PORTISHEAD BRANCH LINE – METROWEST PHASE 1

**Schedule of ExA's recommended amendments to the Applicant's draft DCO
submitted at Deadline (D)6 [REP6-008]**

Approved by: CW Date: 18/07/2019

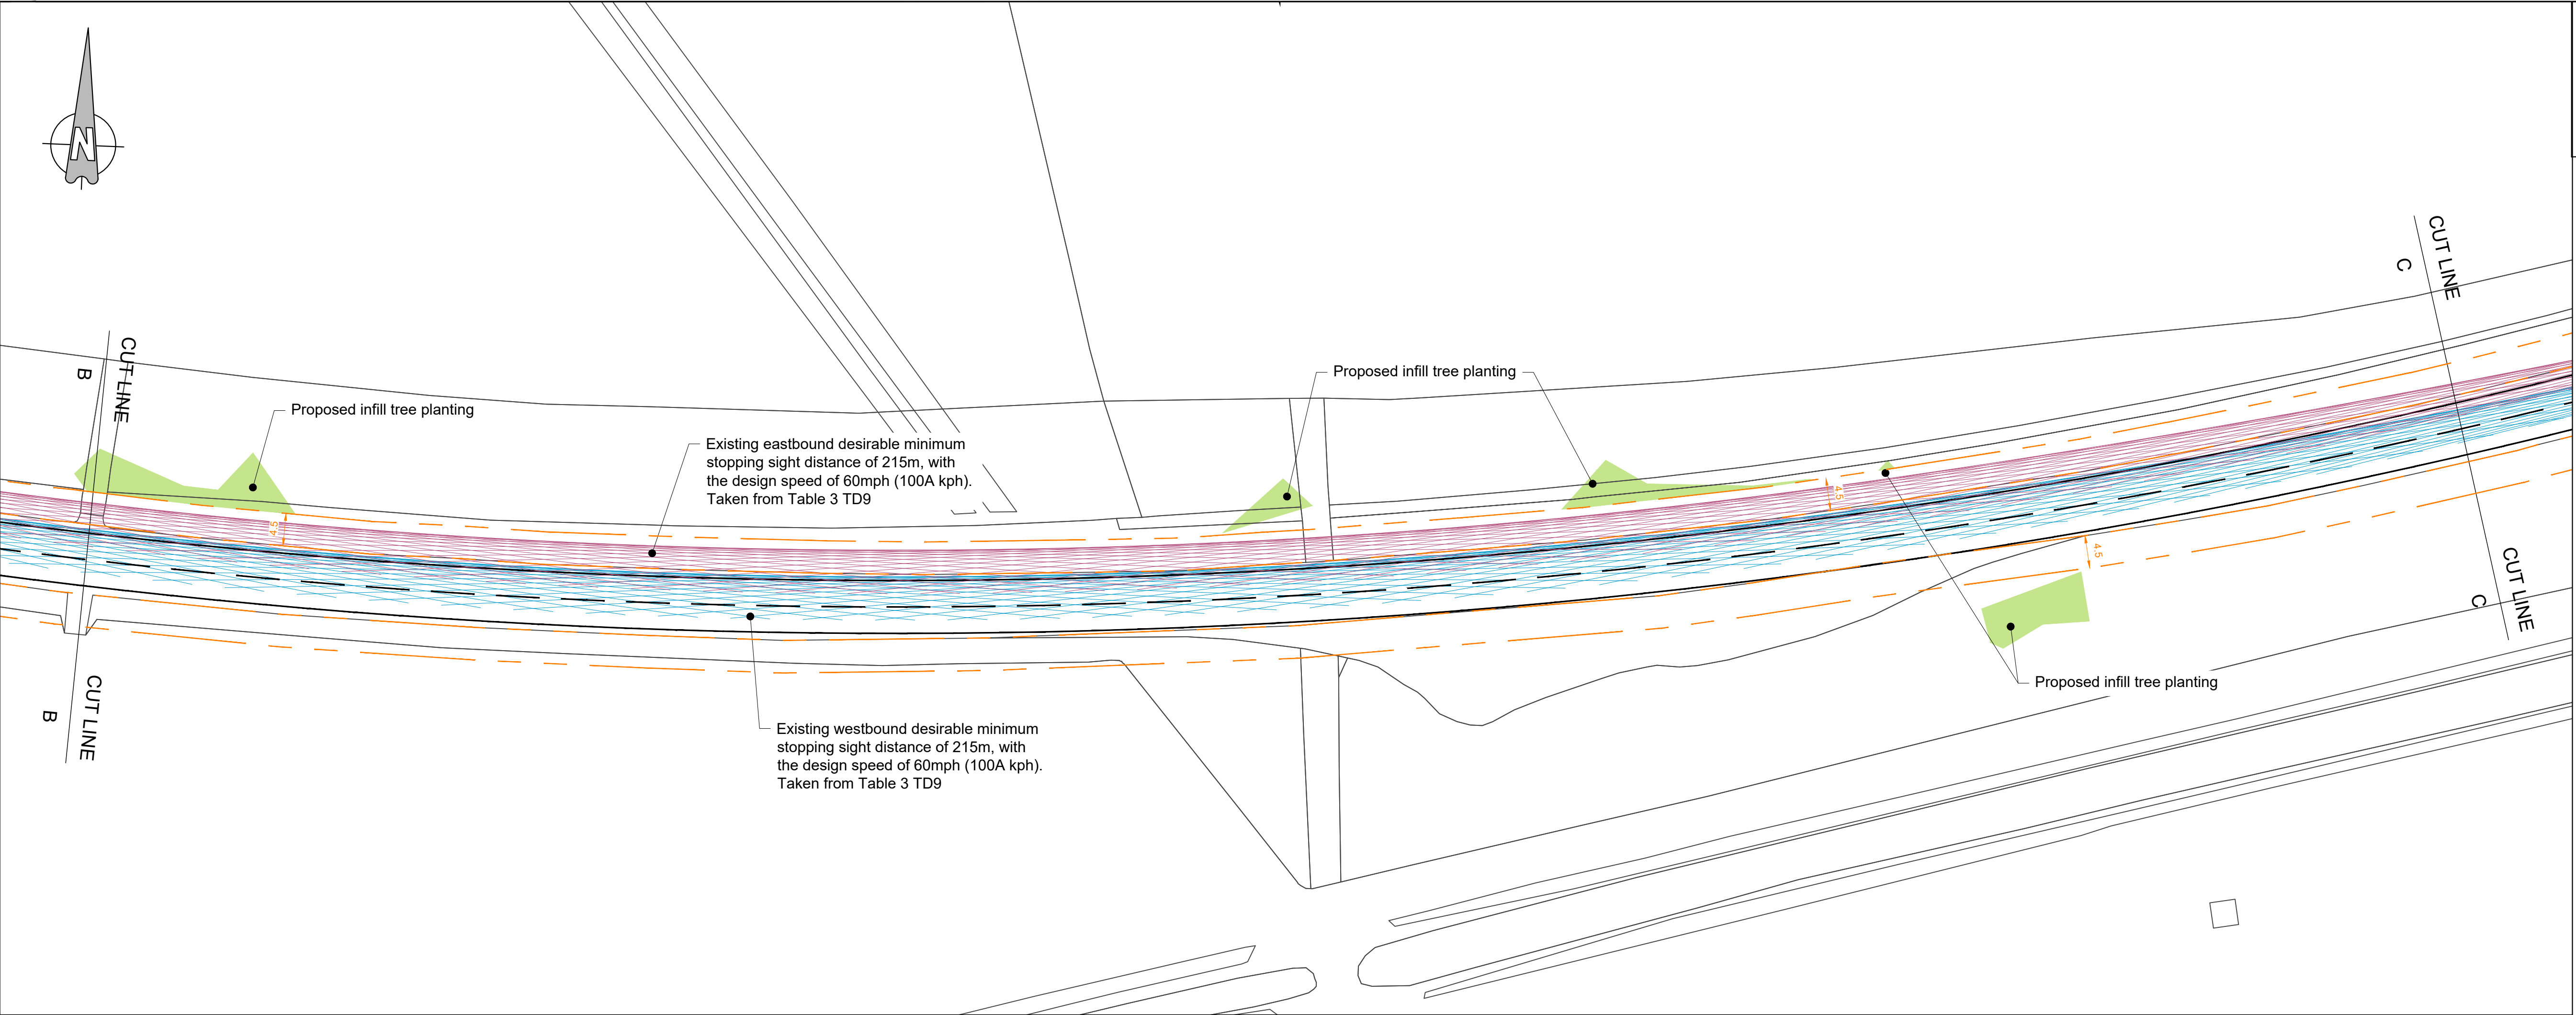
<p>Schedule 2 Requirement 24 <i>For the protection of bats</i></p>	<p>24(1) Work Nos 1, 1A, 1B and 1C must not commence until written details of the proposed tree planting on the A369 Portbury Hundred classified road must have been approved in writing by the relevant planning authority</p>	<p>24(1) Work Nos 1, 1A, 1B and 1C must not commence until written details of the proposed tree planting on the A369 Portbury Hundred classified road must have been approved in writing by the relevant planning authority in consultation with the relevant</p>	<p>As the tree planting is proposed to provide additional foraging for commuting bats the ExA consider that it would be appropriate that Natural England should be consulted on the details</p>

in consultation with the relevant highway authority. The details submitted for approval must accord with the Portbury Hundred location of additional tree planting plans.	highway authority and Natural England . The details submitted for approval must accord with the Portbury Hundred location of additional tree planting plans.	
Schedule 2 Requirement 25 <i>Permanent fencing outside of Avon Gorge Woodlands SAC</i>	25(1) subject to paragraphs (2) and (3) and without affecting requirement 31(4) a stage of the works must not commence until written details of any permanent security fencing to be installed in connection with the that stage, together with a timetable for its installation, have been submitted to and approved by the relevant planning authority. (2) Where new fencing is to be provided that does not fall within a stage, and is outside of the Avon Gorge Woodlands SAC any permanent security fencing	25(1) subject to paragraphs (2) and (3) and without affecting requirement 31(4) a stage of the works must not commence until written details of any permanent security fencing to be installed in connection with that stage, together with a timetable for its installation, have been submitted to and approved by the relevant planning authority. (2) Where new fencing is to be provided that does not fall within a stage, and is outside of the Avon Gorge Woodlands SAC any permanent security fencing to be installed must be of a nature substantially in accordance with the details set	The insertion of this wording would give the Applicant the flexibility to change the fencing if required for operational safety reasons but would mean that Requirement 35 (2) would apply so that it would ensure that in this location any variations to the fencing would not give rise to any materially new or materially different environmental effects from those assessed in the ES
